City of Ryde Submission

Ryde Hospital Redevelopment - SSD-36778089
1 Denistone Road Eastwood

Ryde Hospital Redevelopment:
Concept Masterplan and Stage 1 Site Works

Submission Date: 19 September 2022

WEST ELEVATION - RYEDALE ROAD  
scale 1: 1000

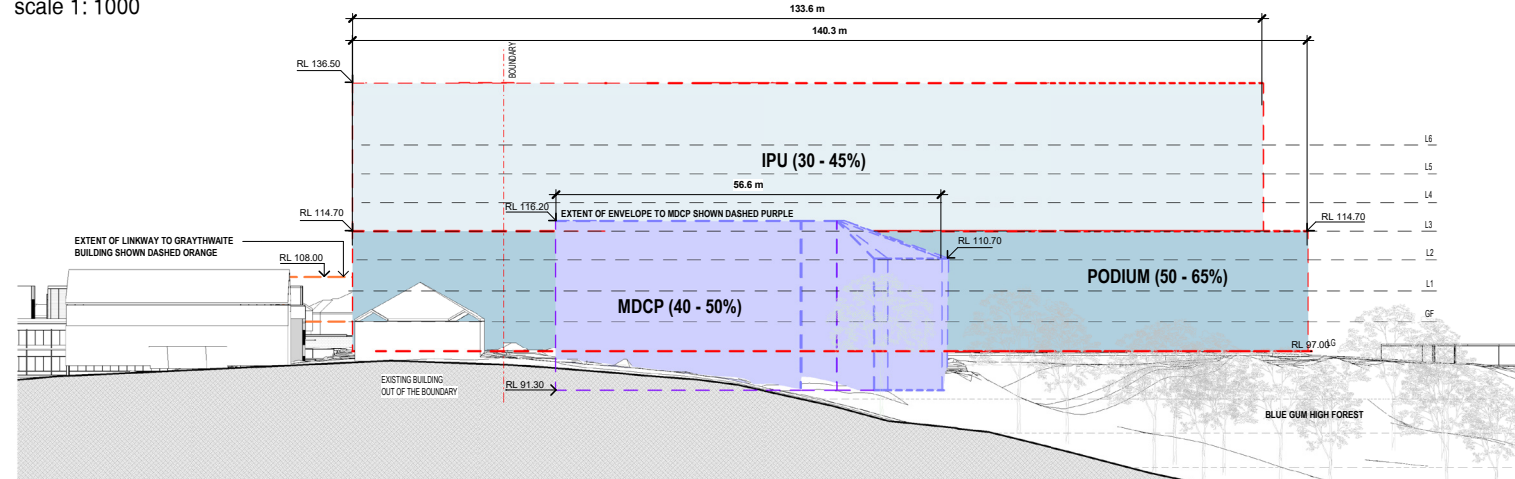
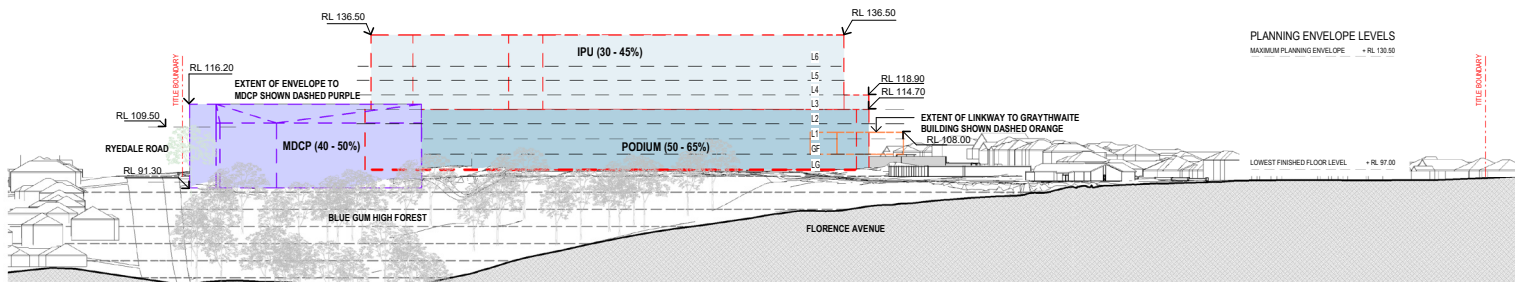
- ii. The formalised access location off Ryedale Road to the new multi-storey carpark will result in sight line issues due to the crest in Ryedale Road. Traffic control measures may be required at this access location. Further comment is sought from Council's Transport Department.
